Appeal Decision

Appeal Ref: APP/Z4718/W/24/3358489

Land adjacent to and part of Parsonage House, Edge Road, Thornhill Edge, Dewsbury, West Yorkshire WF12 0QD

- The appeal is made under section 78 of the Town and Country Planning Act 1990 (as amended) against a refusal to grant planning permission.
 - The appeal is made by Mr Steven Brougham against the decision of Kirklees Council.
 - The application reference is 2024/62/90279/E.
 - The development proposed is a detached contemporary design house.
-

PROPOSED NEW CONTEMPORARY HOUSE ADJACENT TO
 PARSONAGE HOUSE EDGE ROAD THORNHILL EDGE DGBURY
 WF12 0QR FOR MR. & MRS. S BROUGHAM MAY 2024

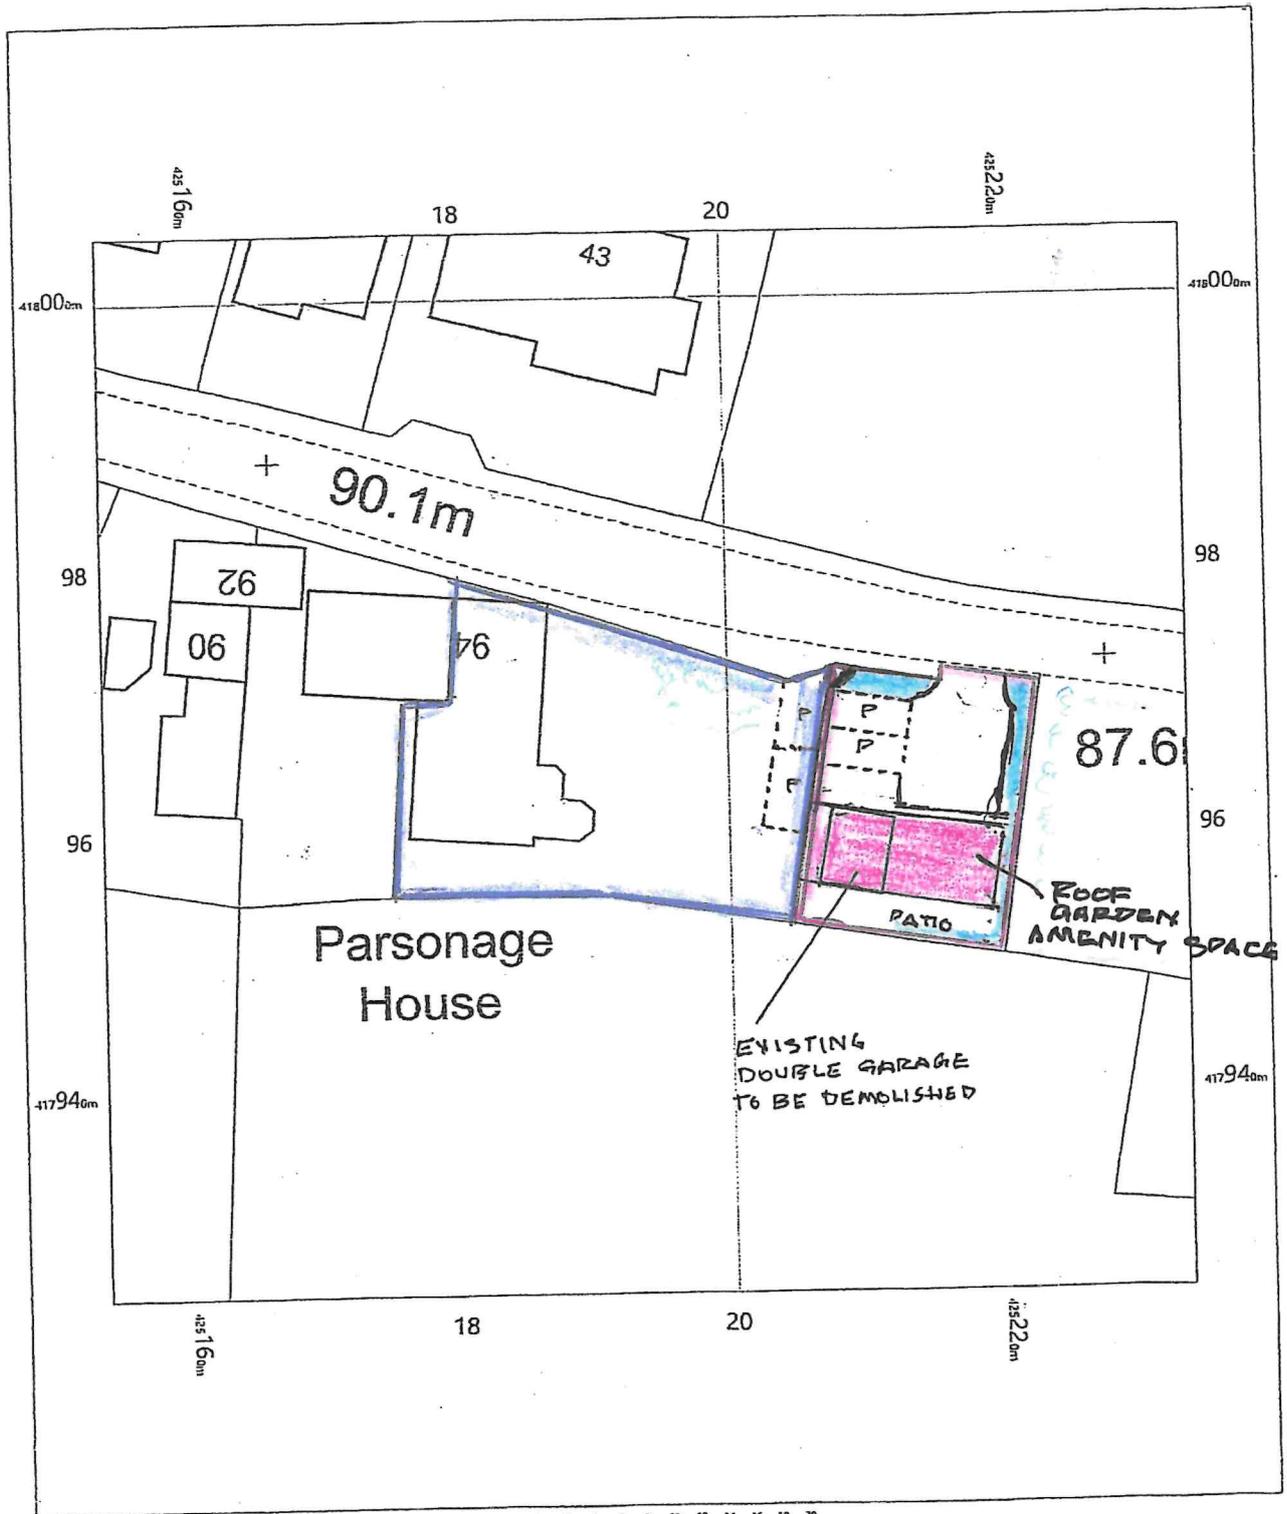
12. The plans do not provide sufficient detail to fully assess the impact of the proposal. No levels are provided to demonstrate the lower floor level of the proposed building or, as a result, its overall relative height. The levels of the two separate parking areas and the new and revised driveways, are not shown. The extent of the changes to the roadside wall are also unclear with regard to providing visibility, particularly from the proposed new access. There is no landscape plan to demonstrate what vegetation would be lost and what would replace it. Whilst some of these matters could be addressed by conditions, levels for the new house and the scale of the works necessary for the parking areas, particularly because of the significant changes in levels, would be necessary as part of a detailed proposal. In this regard, a positive decision could not be reached on the basis of the current details.

13. It would appear that most of the vegetation within the garden, that currently provides an attractive transition from the countryside into the settlement, would be lost. Given the scale of the house, it is likely that it would be publically apparent. Given its use of the full width of the site, it is likely that it would appear cramped and overdeveloped, particularly when considering its edge of settlement/countryside location. The proposed changes to the built form, including the supporting vehicular requirements, would be likely to detract from the current appearance of the site; and from the character and appearance of the area. The loss and limited potential for landscaping, adds to this concern. It would conflict with the design aspirations of LP policy LP24 and the Framework. I have further reservations with regard to LP policies LP32 and LP33 in relation to the landscape setting of the settlement and the loss of trees. In this respect, the proposal would also conflict with Principle 2 of the council's Housebuilders Design Guide Supplementary Planning Document 2021. As the document accords with the design aspirations of the development plan and the Framework, I afford it considerable weight.
